STATE OF NORTH CAROLINA
DEPARTMENT OF TRANSPORTATION

Addendum No. 1

RE: Contract ID: C202355

NC-12 From The Northern Ferry Dock to Ocracoke Village

- SHEET 1 TITLE SHEET
- SHEET 2 & 3 PAVEMENT SCHEDULE
TYPICAL SECTIONS
- SHEET 4 DETAIL SHEET
- SHEET 5 SUMMARY of QUANTITIES

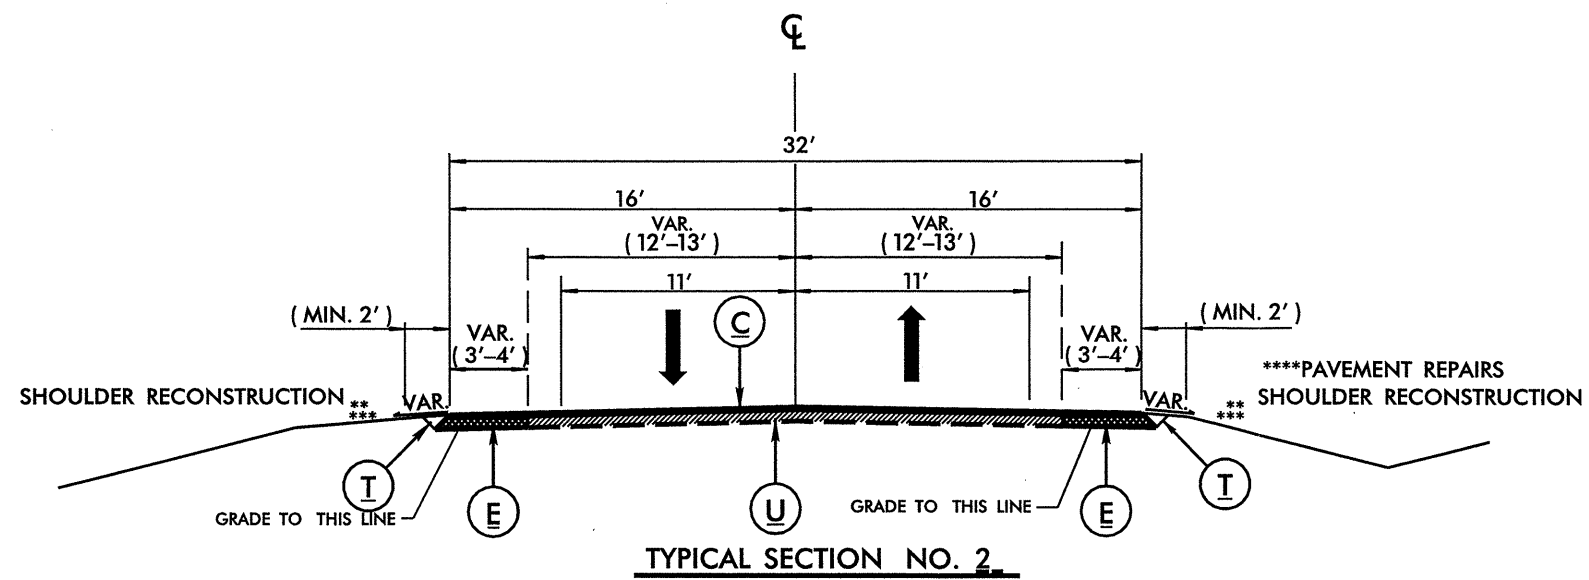
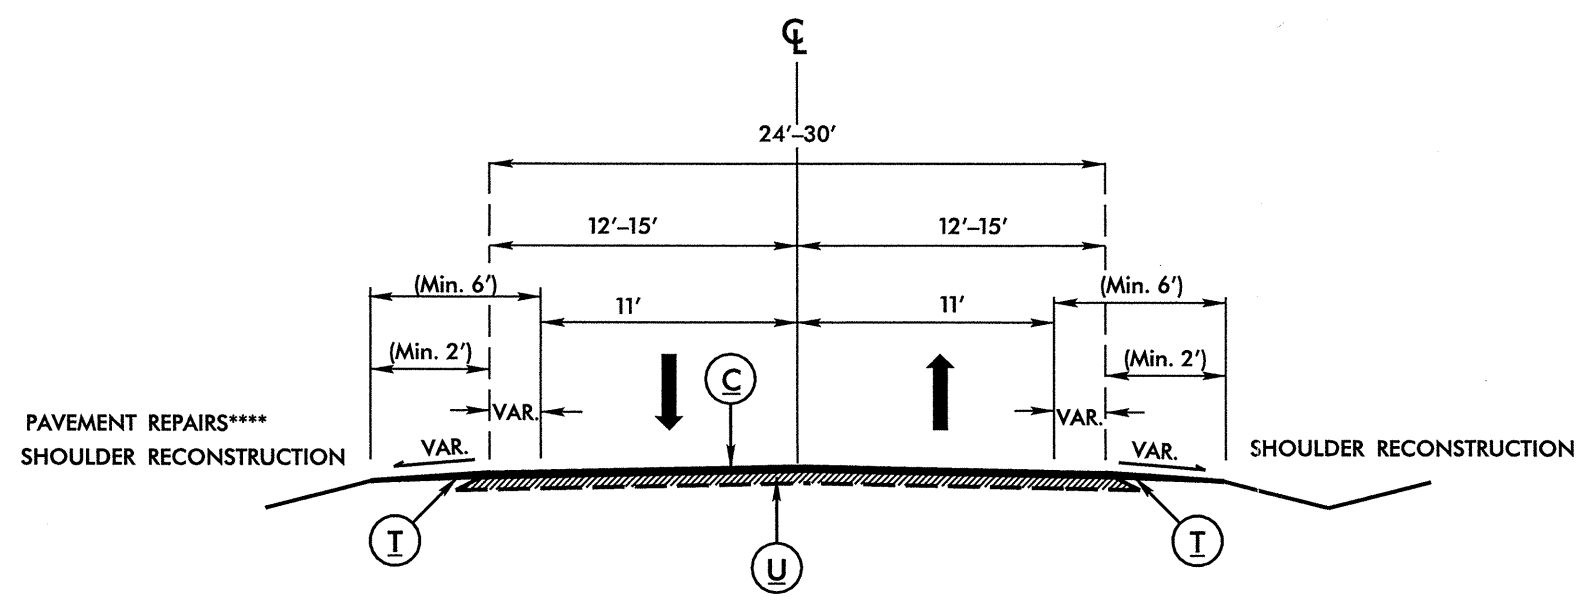
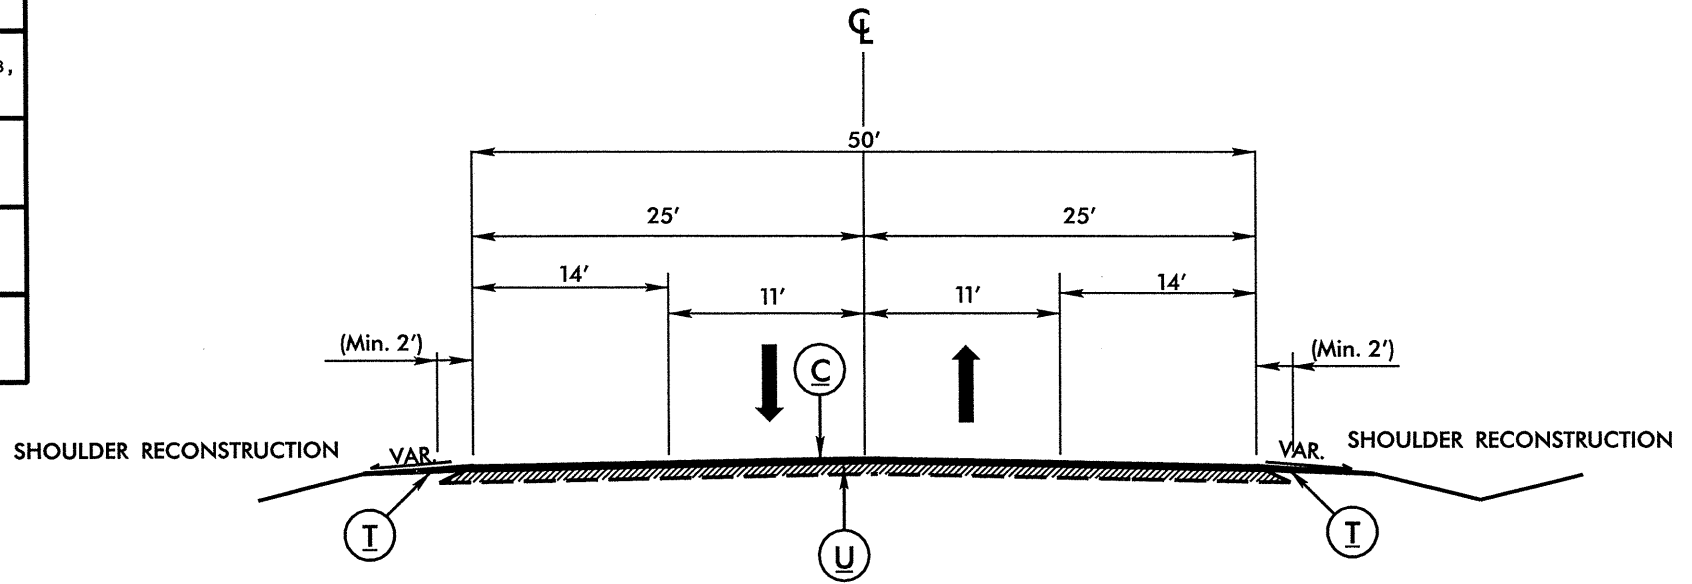
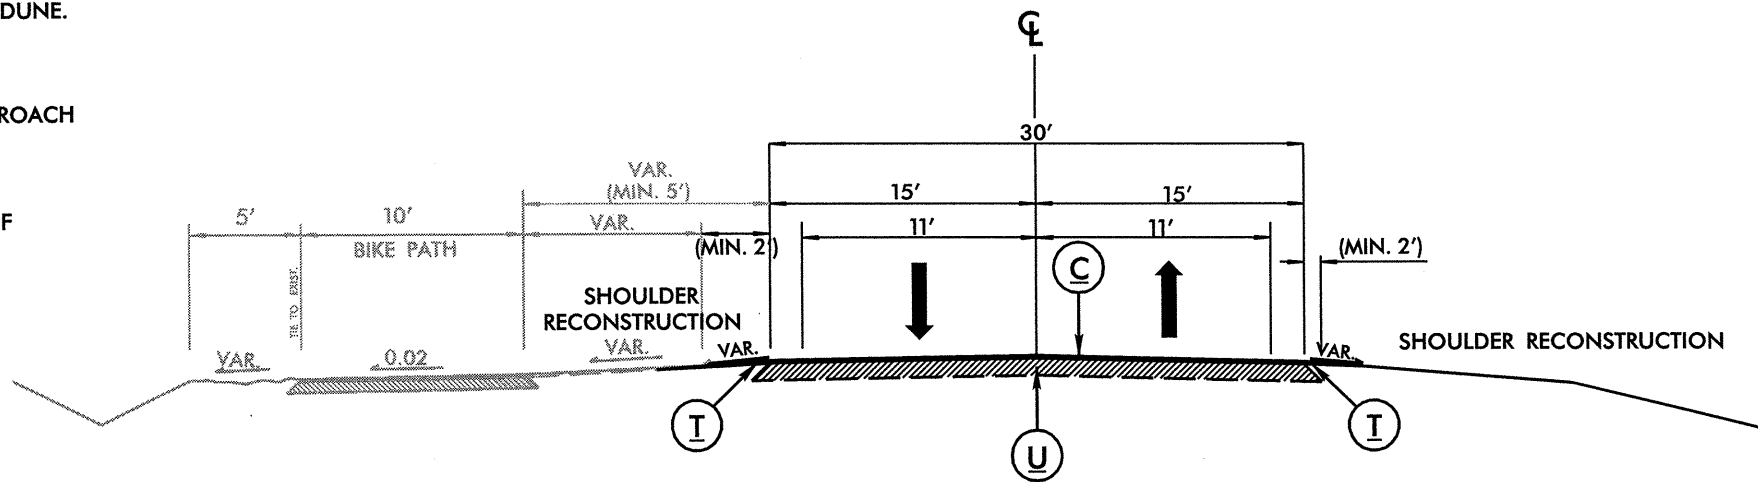
On Sheet Nos. 2 and 3 the note concerning borrow material has been deleted. Please void Sheet Nos. 2 and 3 and staple the revised Sheet Nos. 2 and 3 thereto.
